DEVELOPMENT REVIEW BOARD
TRANSPORTATION DEVELOPMENT

DRB Project Number: 1002739
Anderson Heights

SUBJECT: Amended Preliminary Plat, Amended Site Plan for Subdivision, Sidewalk Deferral

Project: Heritage Trails
AKA - Anderson Heights Unit 4A Agenda Item No: 12

MATCHLINE B

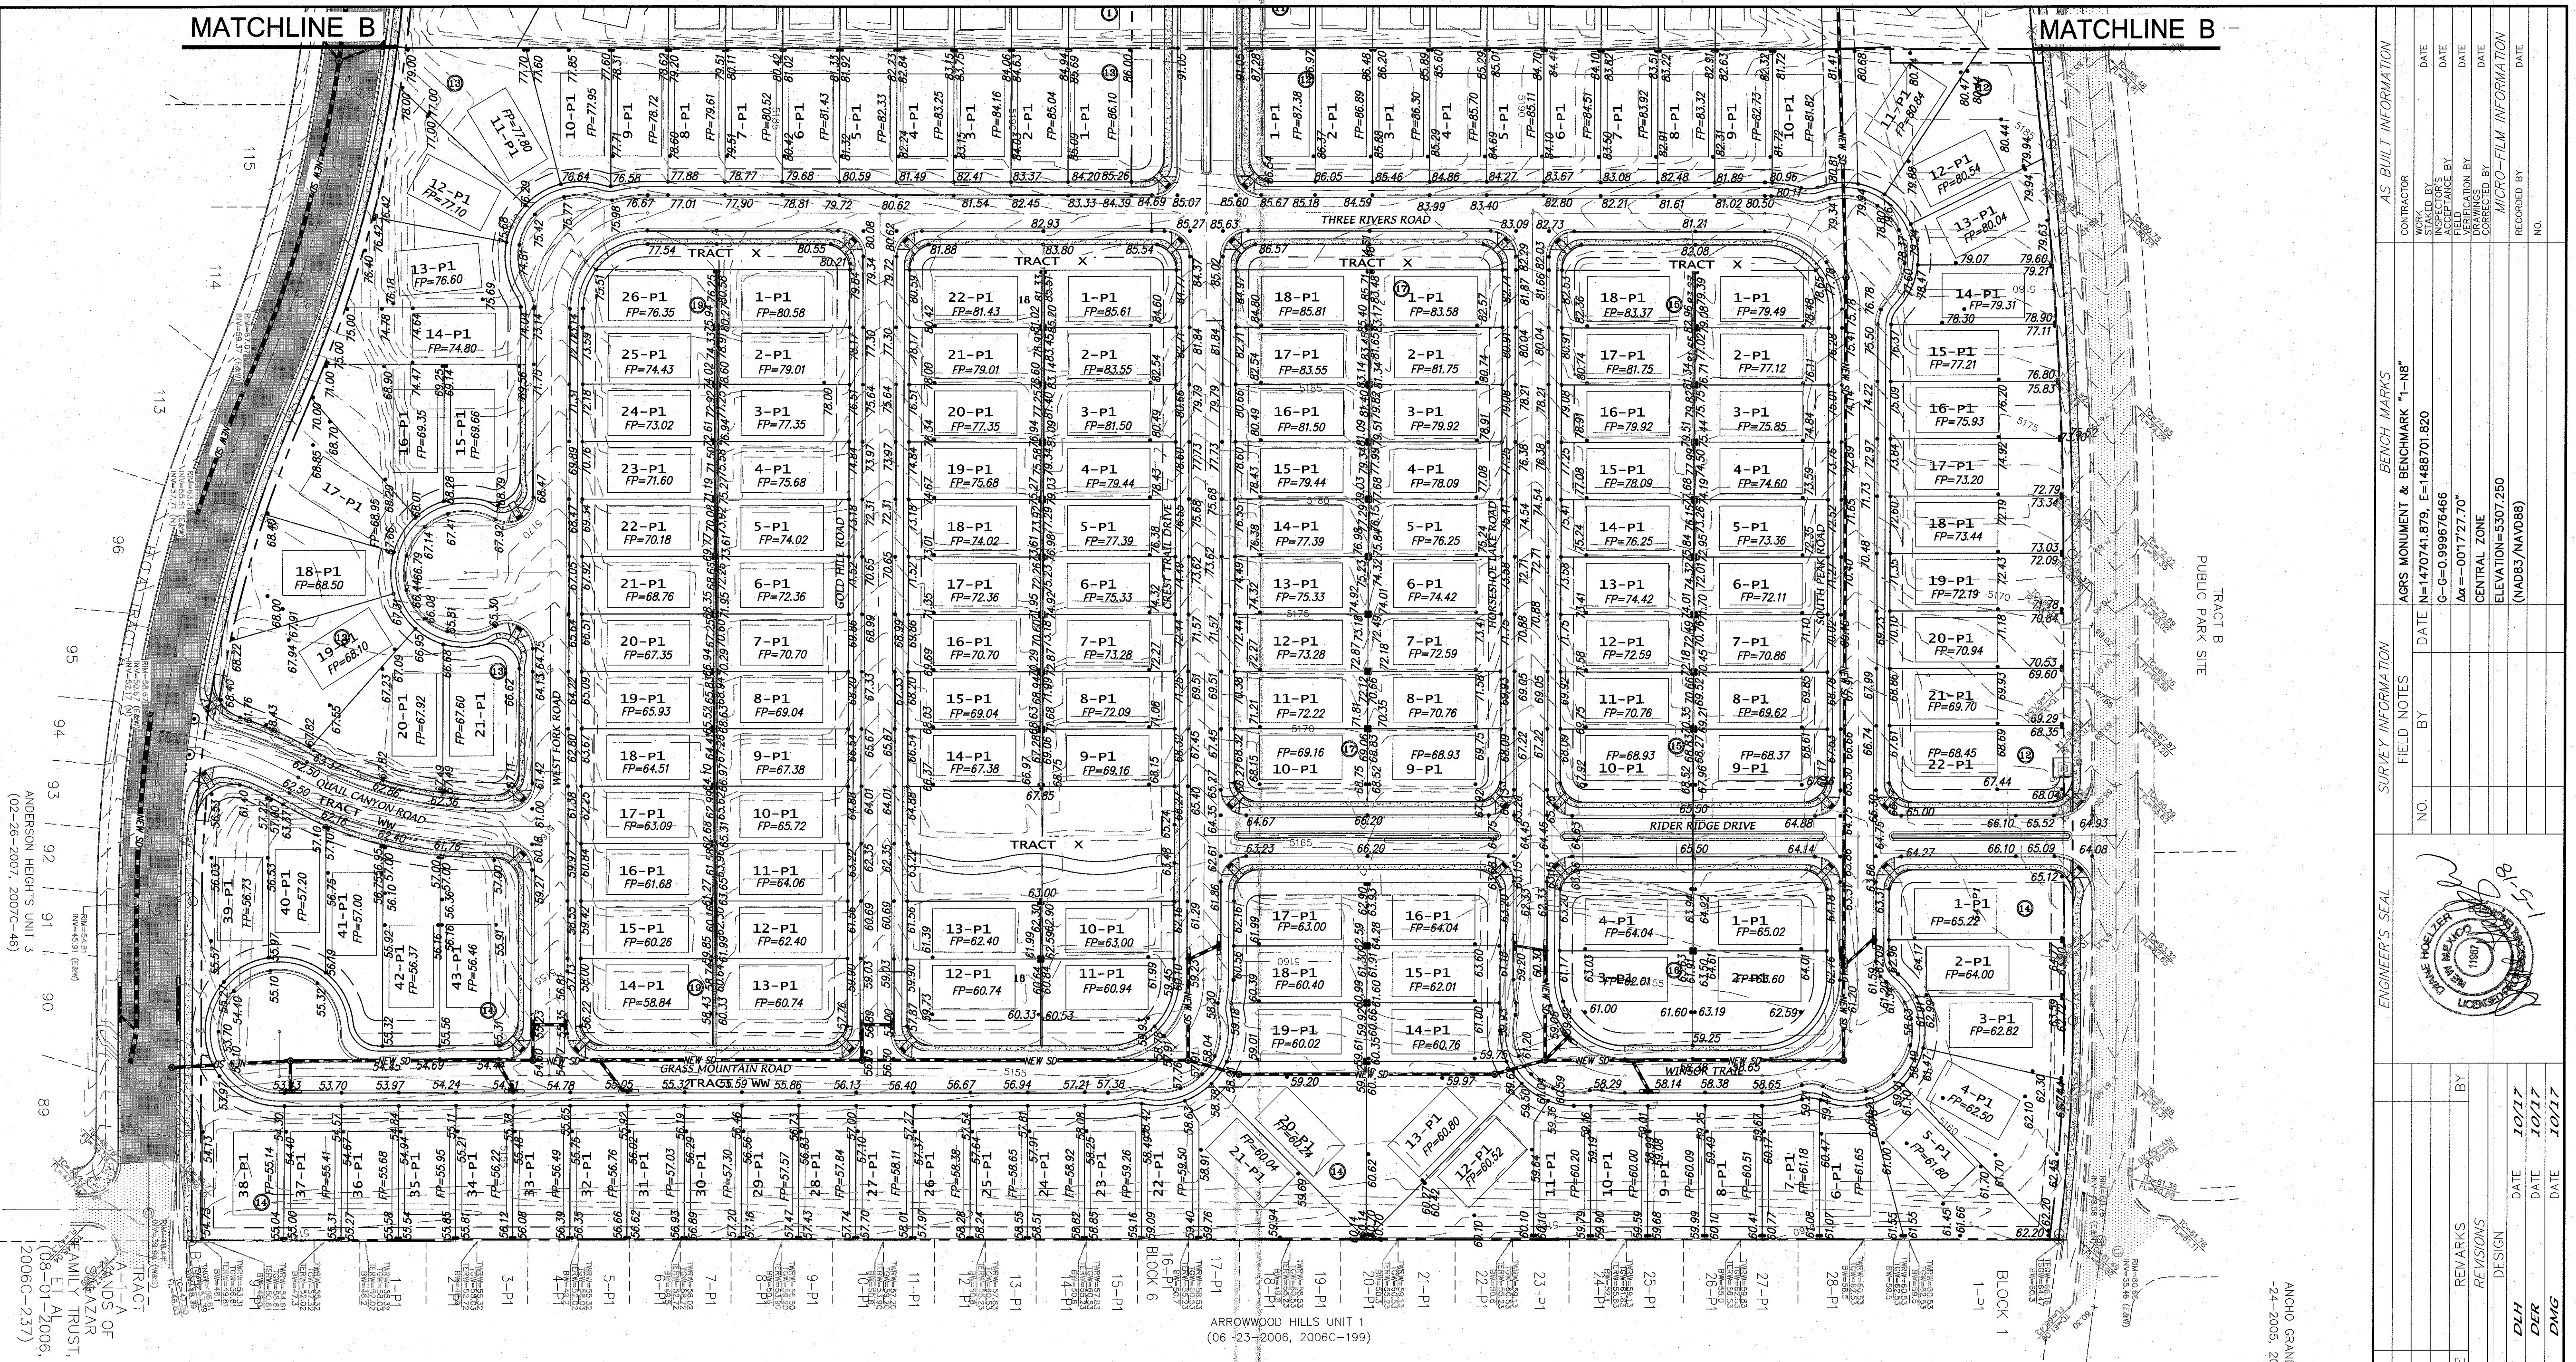
- An approved Drainage Report and Grading and Drainage plan is required.
- A central First Flush Pond (or fee in lieu) will be required.
- Add units 1-3 to the title of the infrastructure list.
